Hillpointe Apartments Site Development Plan

Date: June 4, 2026

Subject: Secondary Emergency Access Requirements – Hillpointe Apartments (PPR2613)

EMERGENCY ACCESS FROM PETERSON ROAD
(STA. 10+00 - 15+53)

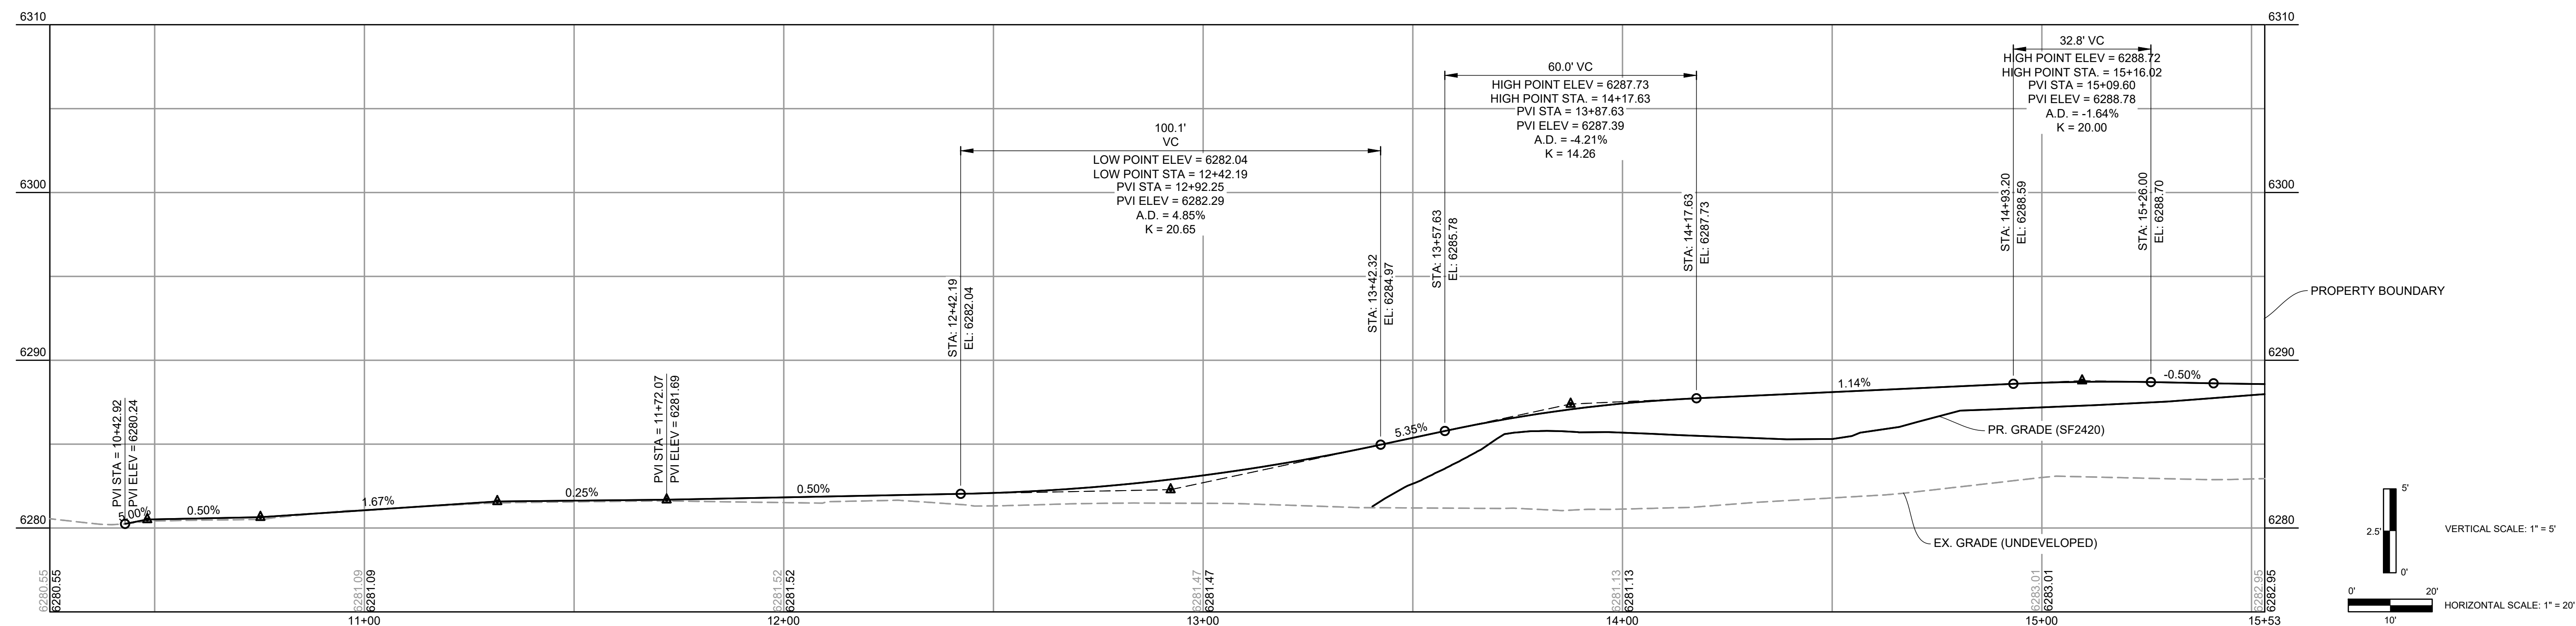
The proposed secondary emergency access is identified as an emergency vehicle-only access route and shall meet the following minimum criteria:

- Minimum sixteen (16) foot unobstructed roadway width.
- Minimum sixteen (16) foot clear gate opening width.
- Knox access and approved emergency gate operation.
- Minimum vertical clearance of thirteen (13) feet six (6) inches.
- Maximum roadway grade of ten percent (10%), unless otherwise approved.
- Minimum turning radii of twenty-five (25) feet inside and fifty (50) feet outside.
- All-weather driving surface designed to support the largest responding fire apparatus.
- Roadway structural section designed by the project engineer and capable of meeting HS-20 loading requirements or equivalent fire apparatus loading criteria.

CHFD acknowledges HR Green's proposed emergency access consisting of a sixteen (16) foot-wide compacted aggregate roadway designed for all-weather use. Final roadway design, aggregate section, compaction requirements, drainage, and structural capacity shall be demonstrated by the project engineer and approved by the applicable reviewing agencies.

Pursuant to LDC § 6.3.3(C)(3)(a), CHFD requests that emergency access design provides reliable emergency responder access and support emergency evacuation operations. This includes evaluation of roadway connectivity, access restrictions, gate operation, and other features that may affect emergency response times, firefighter safety, and public safety.
